re: Grading and Site Servicing Plan Review
Proposed Self Storage Development
75 Michael Cowpland Drive – Ottawa, Ontario

date: December 21, 2023

file: PG3798-MEMO.02 Revision 4

IBI GROUP logo and contact information: Suite 400 - 333 Preston Street, Ottawa, ON K1S 5N4, Canada.

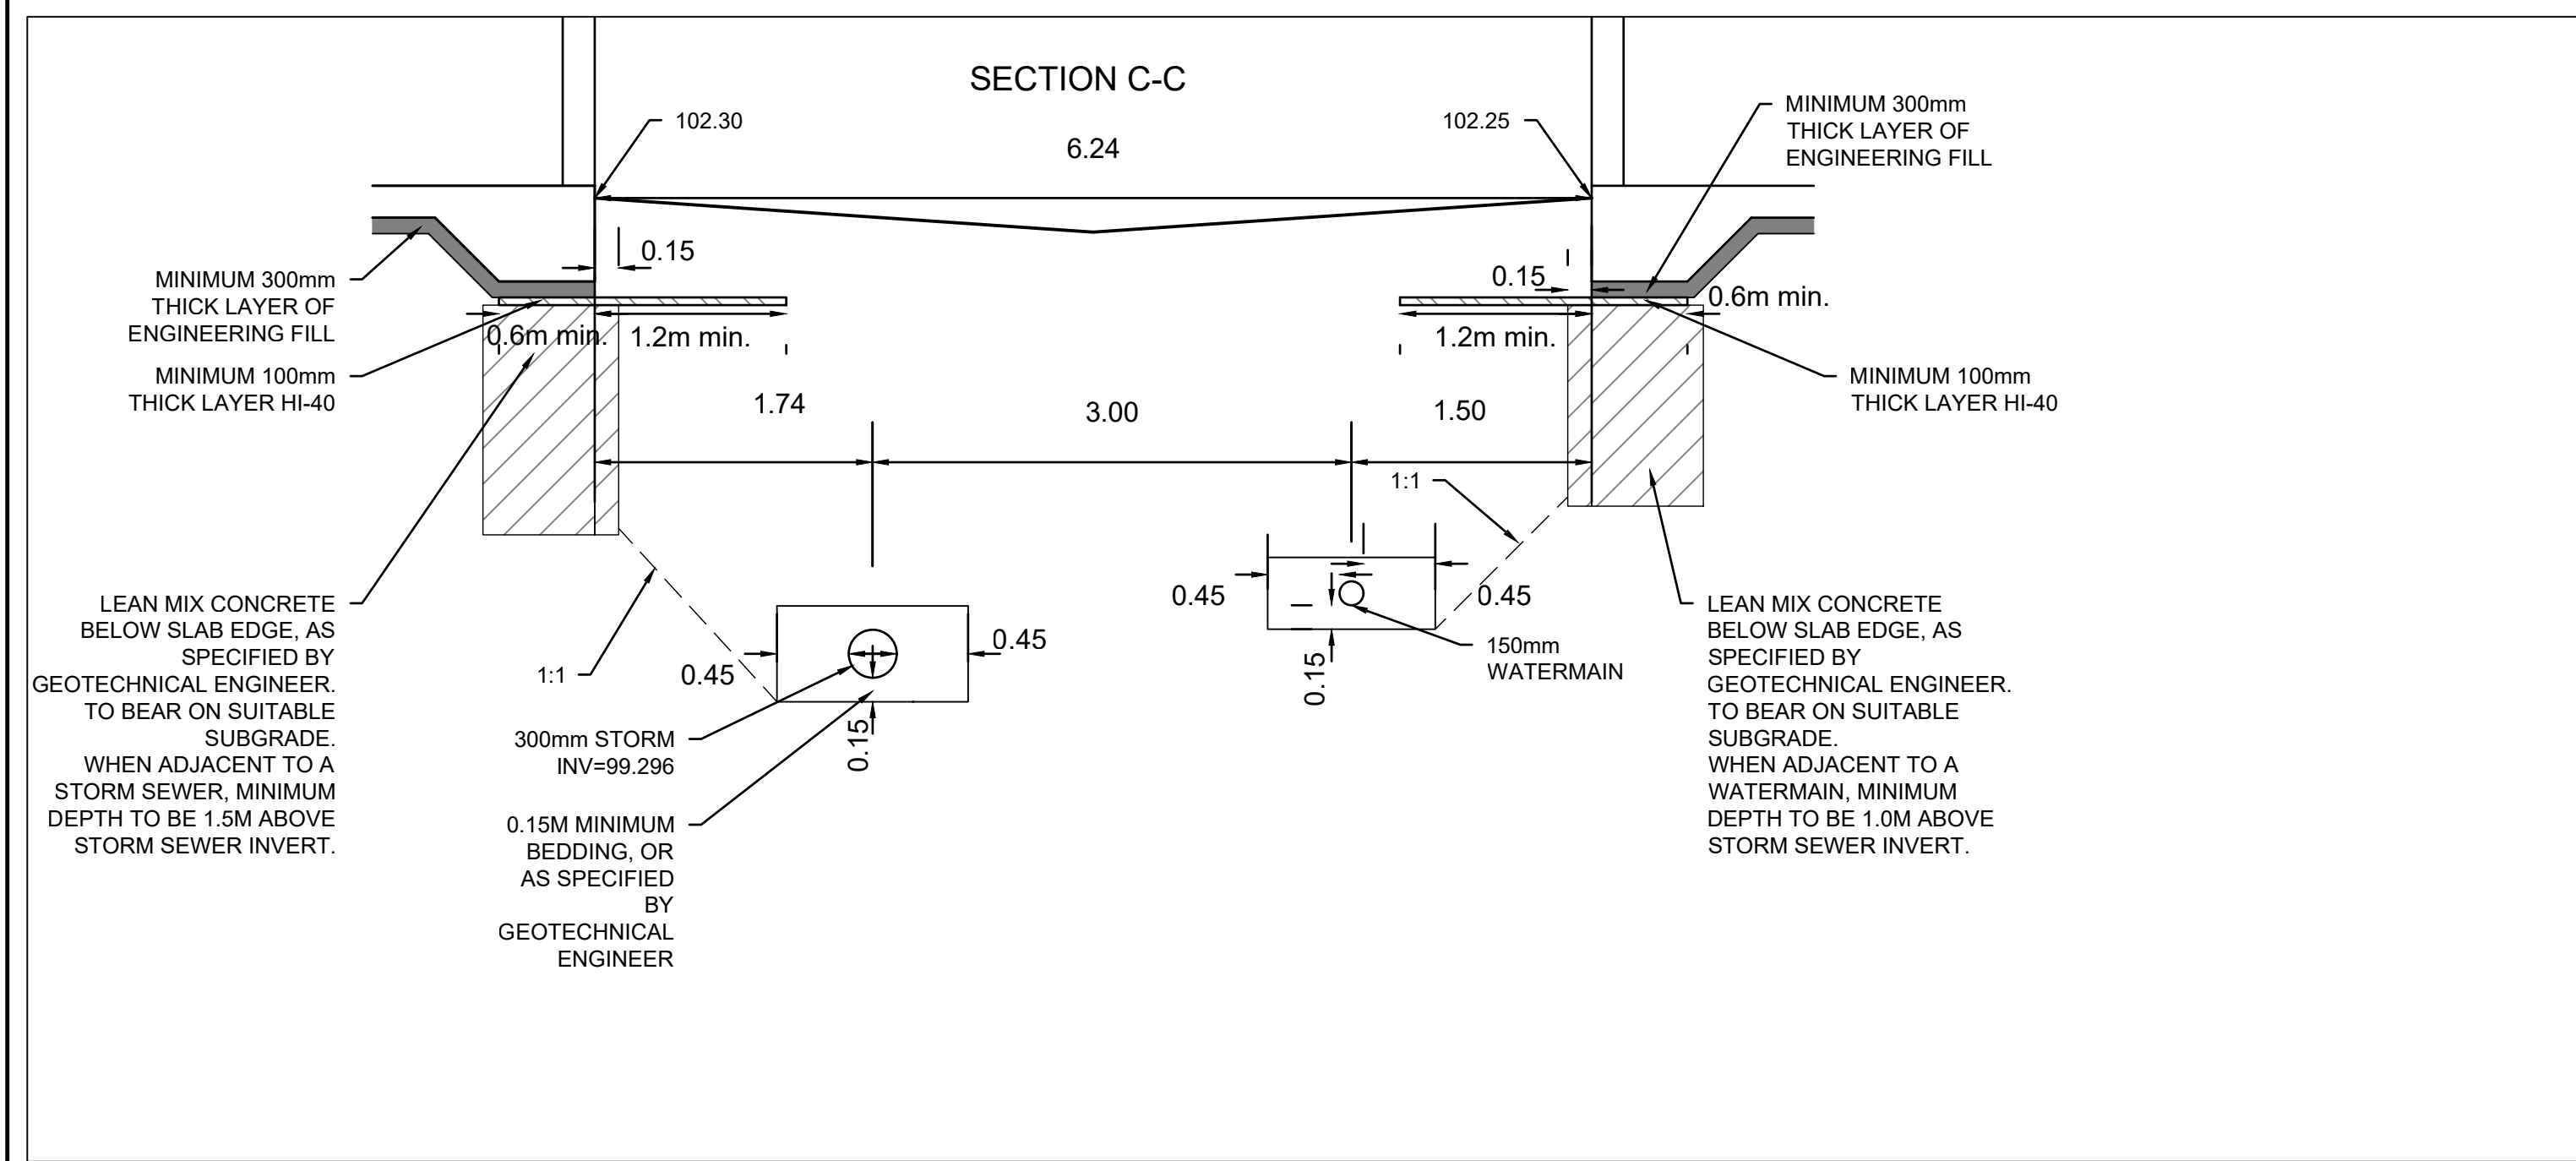
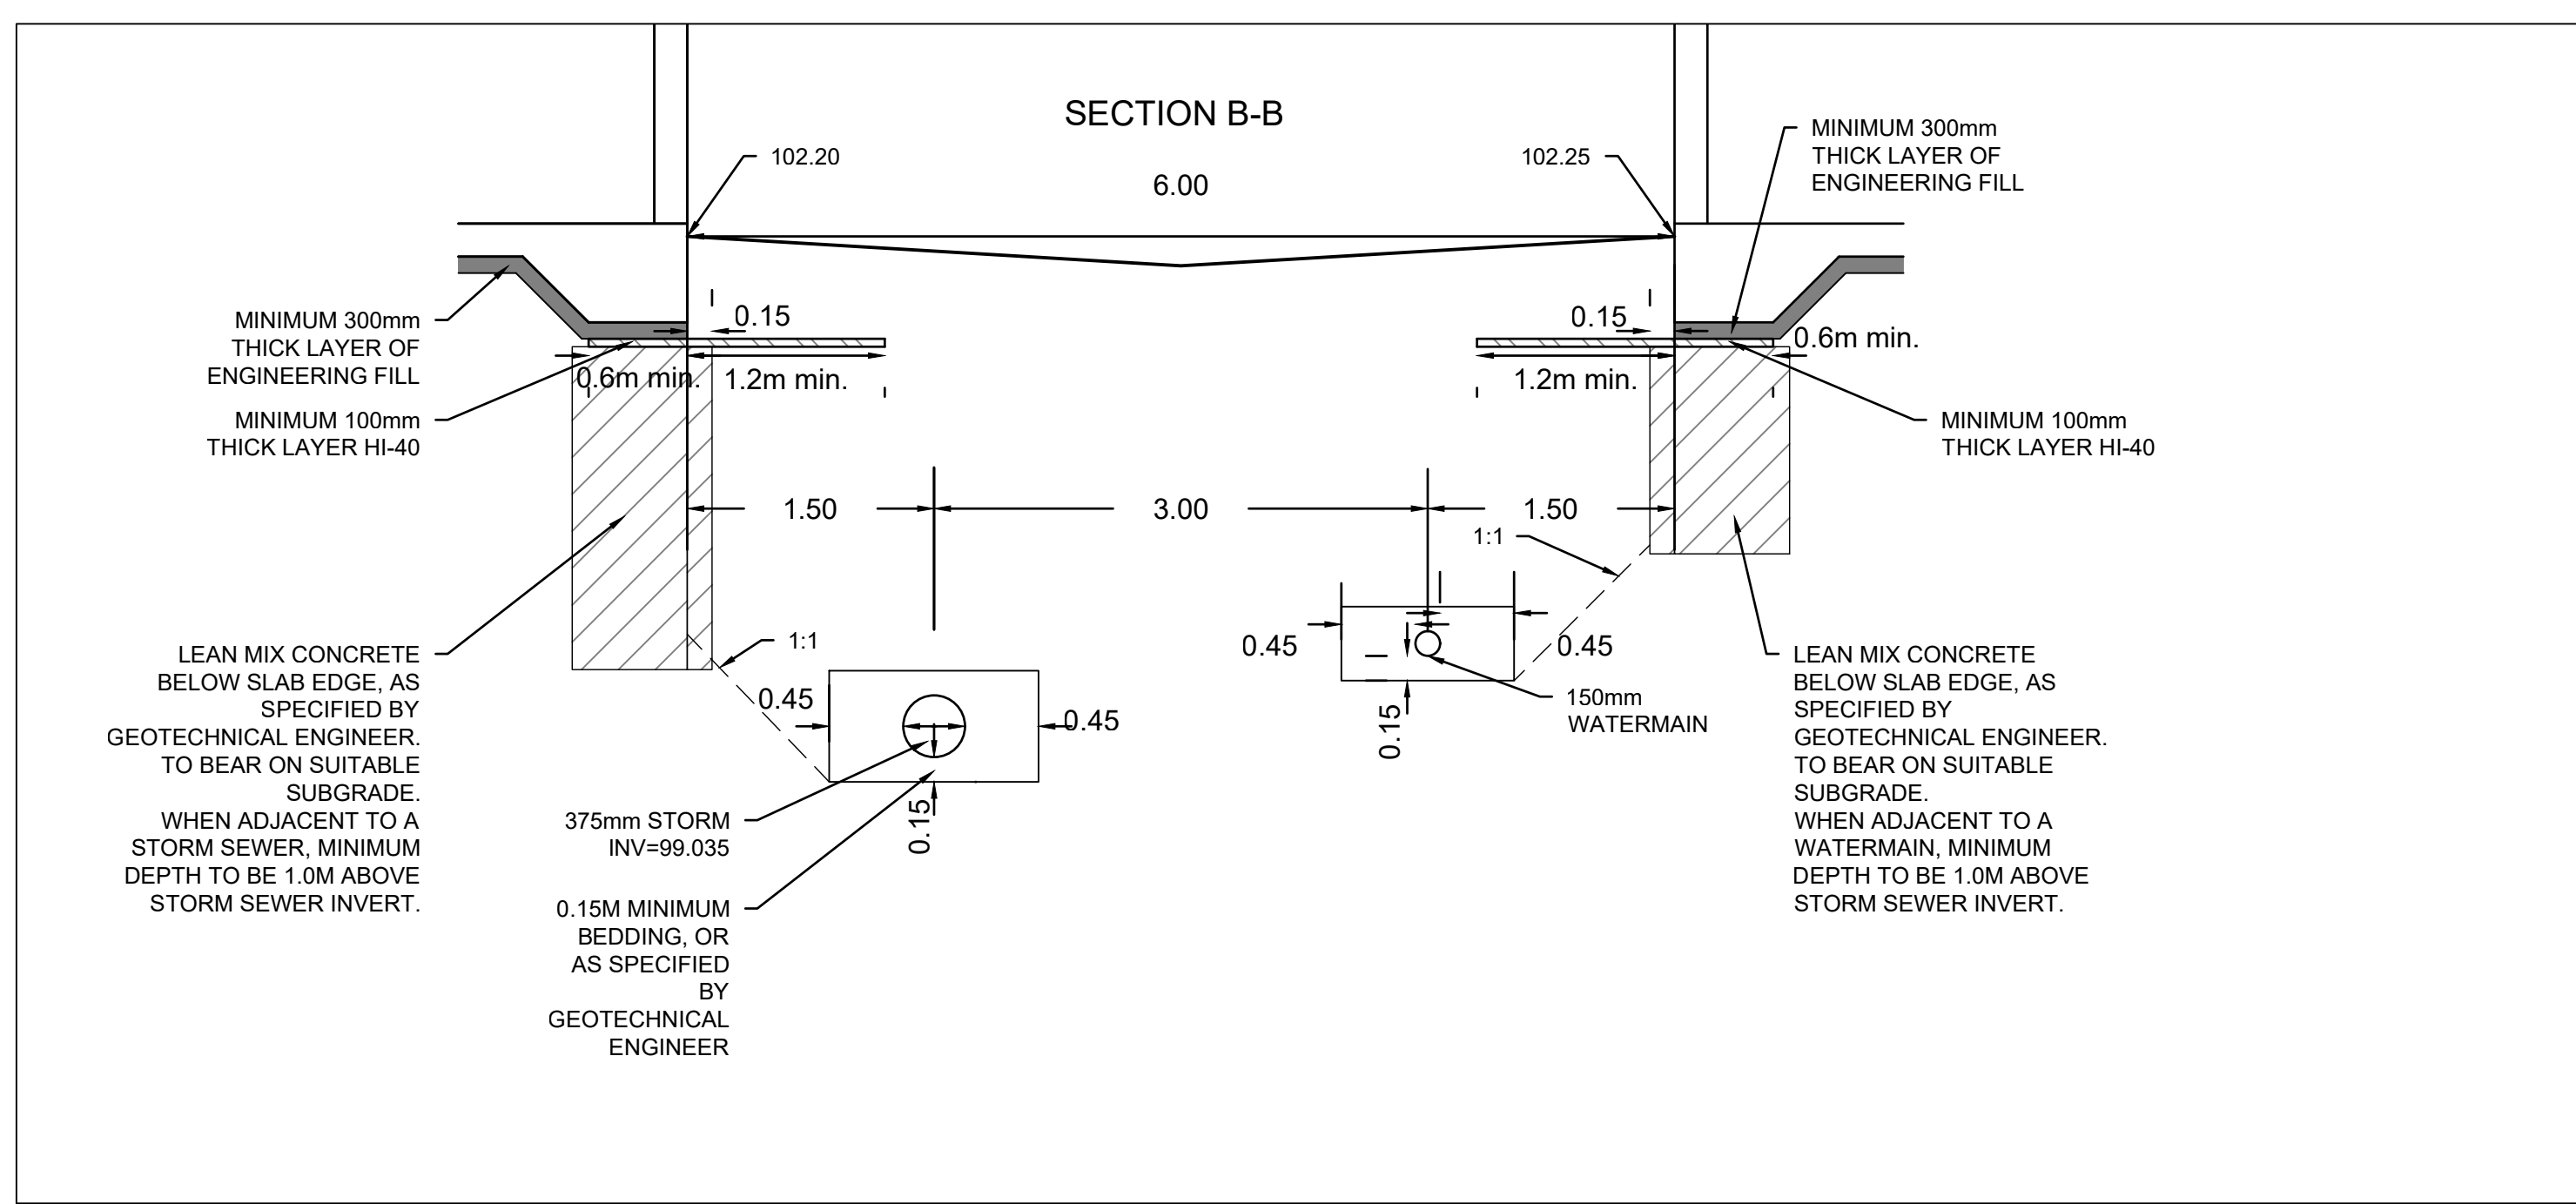
Based on our review of the above noted site service plans, the majority of the design details are considered to be acceptable from a geotechnical perspective. All proposed service pipes are sufficiently covered by adequate soil cover with no frost protection required.

Upon discussions with the design team, the proposed thickened edge slabs are now proposed to be placed on vertical, concrete in-filled trenches where adjacent service pipes are proposed with the lateral support zone of the proposed structures. These trenches would lower the lateral support zone of the slabs below the service trenches ensuring that the proposed buildings are protected should future excavation be required for the proposed services for maintenance purposes.

Due to the anticipated depth and proximity of the proposed service pipes to the proposed thickened edge slab footprints, it is expected the lateral support zones for the proposed structures will be negatively impacted by the service installation works. Further, future maintenance that could be considered throughout the proposed service alignments would require trenches that would impact the proposed buildings lateral support zones. Based on this, it is recommended to lower the lateral support zones for thickened edge footings located adjacent to impacting service alignments. This may be accomplished by sub-excavating a near-vertical trench located directly below the overlying footing footprint and in-filled with minimum 17 MPa lean-concrete.

It is recommended the near-vertical trenches extend a minimum of 150 mm horizontally beyond the overlying footing footprint. Based on our review, the lean-concrete trench detail has been incorporated satisfactorily into the above-noted site servicing plans. The recommended perimeter thickened-edge slab foundation insulation detail is depicted below for the proposed storage structures and has been incorporated satisfactorily in the above-noted site servicing plans. The placement of the lean-concrete trench and rigid insulation should be reviewed and approved by Paterson personnel at the time of construction.
